Re: 131 Piney Grove Rawls Road Harnett County NC

Permit # Pending JAMPE Job Number 2401-06

Review of existing footing and foundation wall construction for renovation / re-construction to up to ten foot wall height.

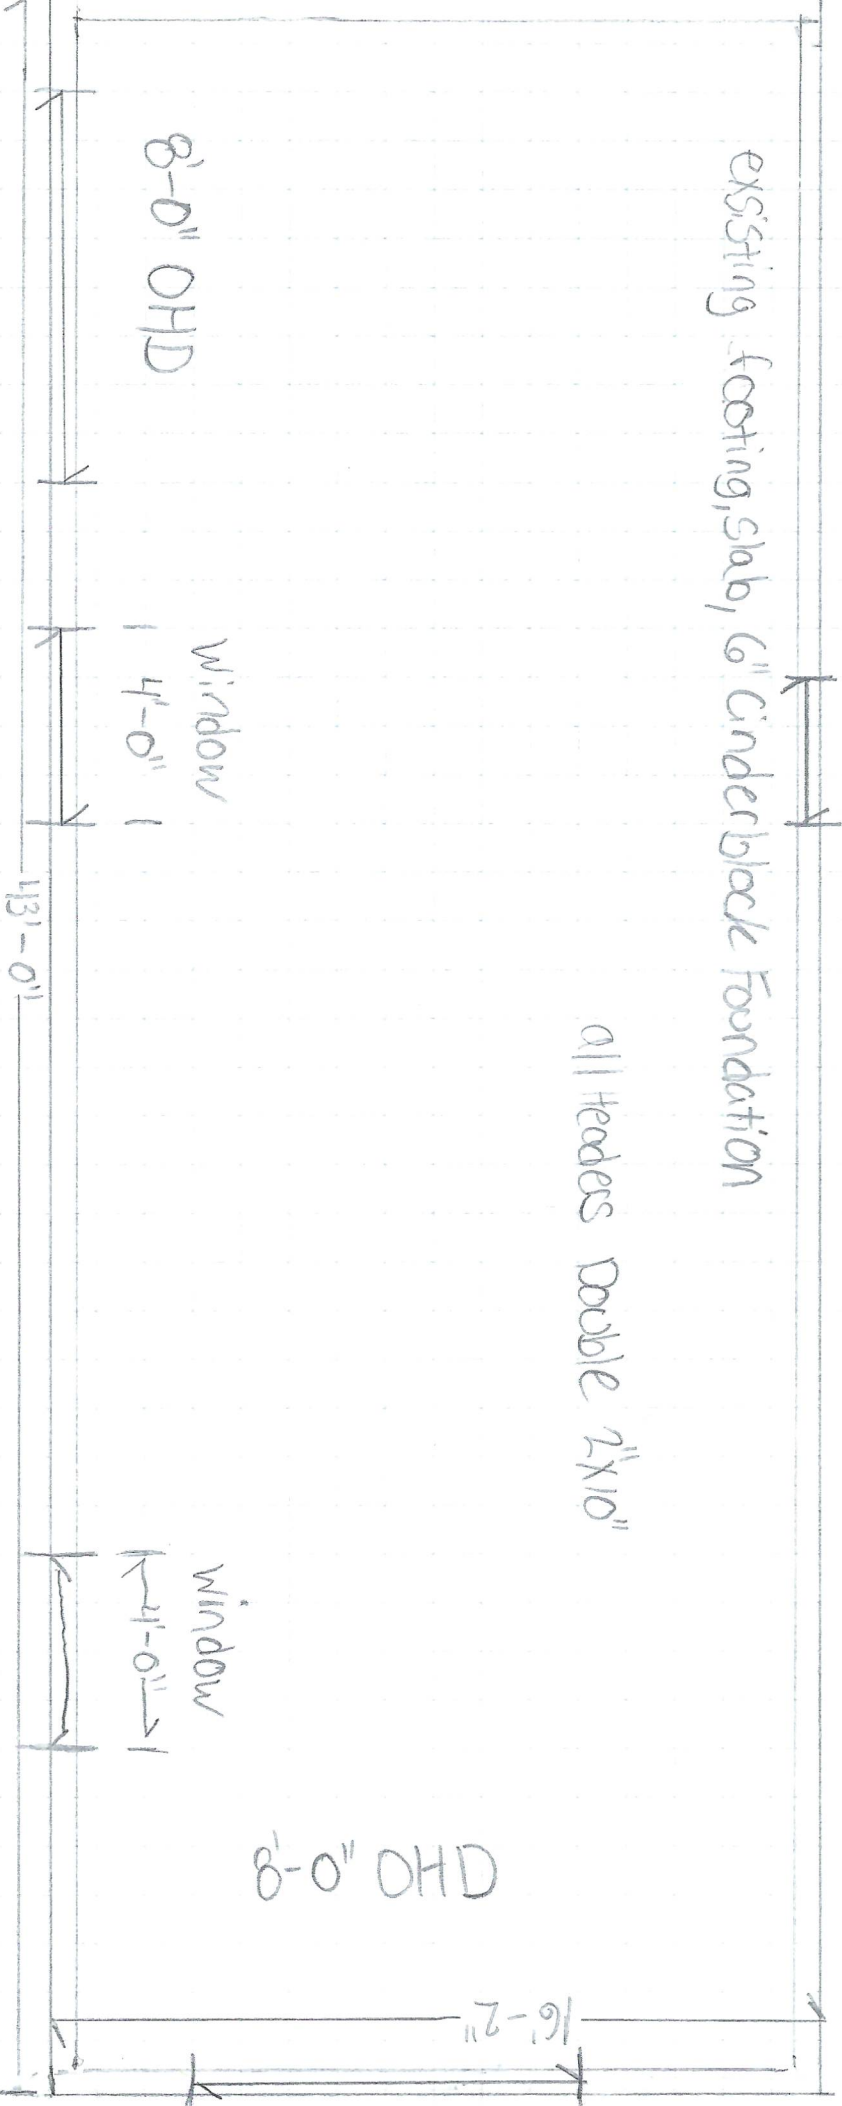
Framing of main door opening will constitute Portal Framing. Frame opening with 7/16 OSB. Lap OSB from top plate down full eight foot or nine foot sheet prior to opening cut-out. Nail with 8d nails at three inches on center ends / edges and six inches on center in field.

Stem Walls each side of garage door opening to be anchored to footing with (two) 5/8" threaded rods embedded four inches and epoxied through bottom sill plate and anchored with 2" x 2" x 3/16" square washers.

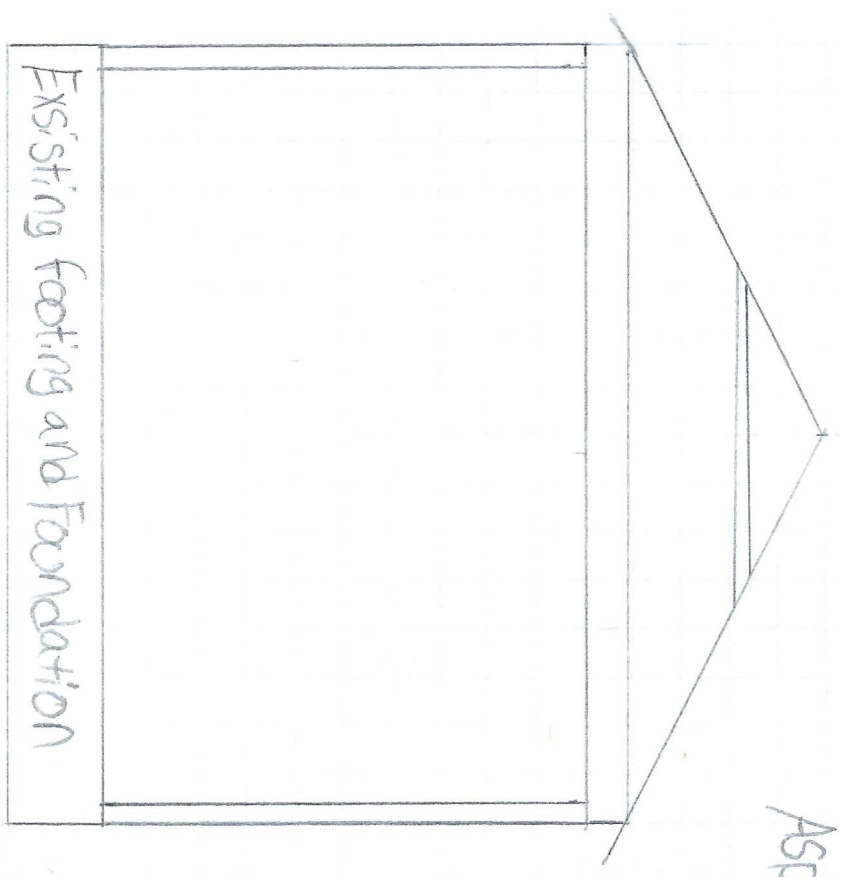
Footing verified to up to required 12" frost depth and minimum of 12 inch thickness.
Maximum load $3(79) + 10(14) + 12/2(20+25) = 647$ plf $(1.4) = 950$ plf / $12/12 = 950$ psf
Existing footing is adequate for expected loads and conditions.

Framing at 2 x 6 @ 16 with ten foot #2 spf or better will require purlins at maximum eight foot on center or at nine foot panel ends.
